Recommendation Report for Planning Permission

REF NO: BR/13/25/PL

LOCATION: Land opposite 19 London Road
Bognor Regis
PO21 1PQ

PROPOSAL: Installation of 1 No. new communications kiosk with integrated defibrillator and advertising display. This application is in CIL Zone 4 (Zero Rated) as other development.

Elevations

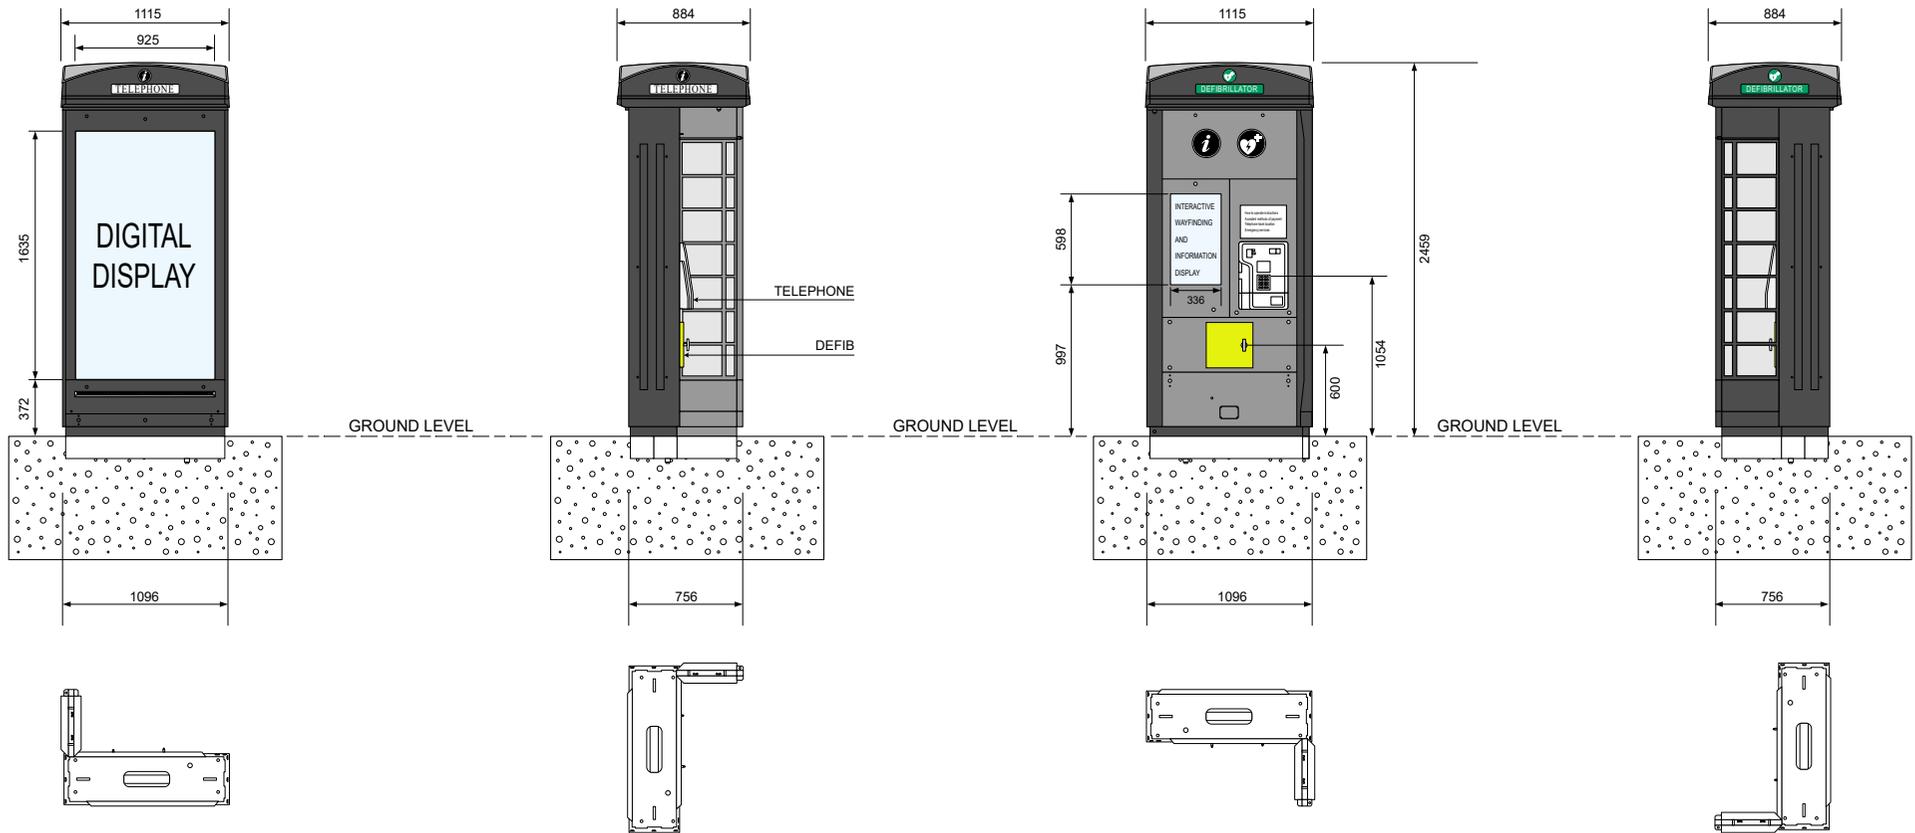
The current application seeks permission for the installation of a communication kiosk with a defibrillator and advertising display. The kiosk structure would have a height of 2.5m, a depth of 1.09m and a width of 0.7m. The internal structure would be constructed from stainless steel with a black steel powder coated outer cladding. The kiosk would also have a 1.6m by 0.9m Liquid Crystal Display (LCD) for advertising which would be recessed behind a 9mm toughened laminated safety glass. A side panel with glazing is proposed.

The Integrated Digital Display is for advertising purposes and would portray static advertising images that would change every 10 seconds. The kiosk is proposed in a cluttered retail area with advertising/hoardings on either sides of London Road. The LHA have recorded no objection to the works, however as the location of the kiosk would not be suitable, and the display panel for advertising would increase the prominence of the kiosk and the proposal would result in harm to the character of the area.

The proposed kiosk, by reason of its siting would be within close proximity to existing public seating and street furniture, resulting in additional clutter within the street scene of London Road. The kiosk would be a visually obtrusive form of development, detracting from the existing shopfronts and would result in demonstrable harm to the character of the locality and visual amenity of the street scene. The proposed development is therefore contrary to Arun Local Plan policy D DM1 and the NPPF (2024).
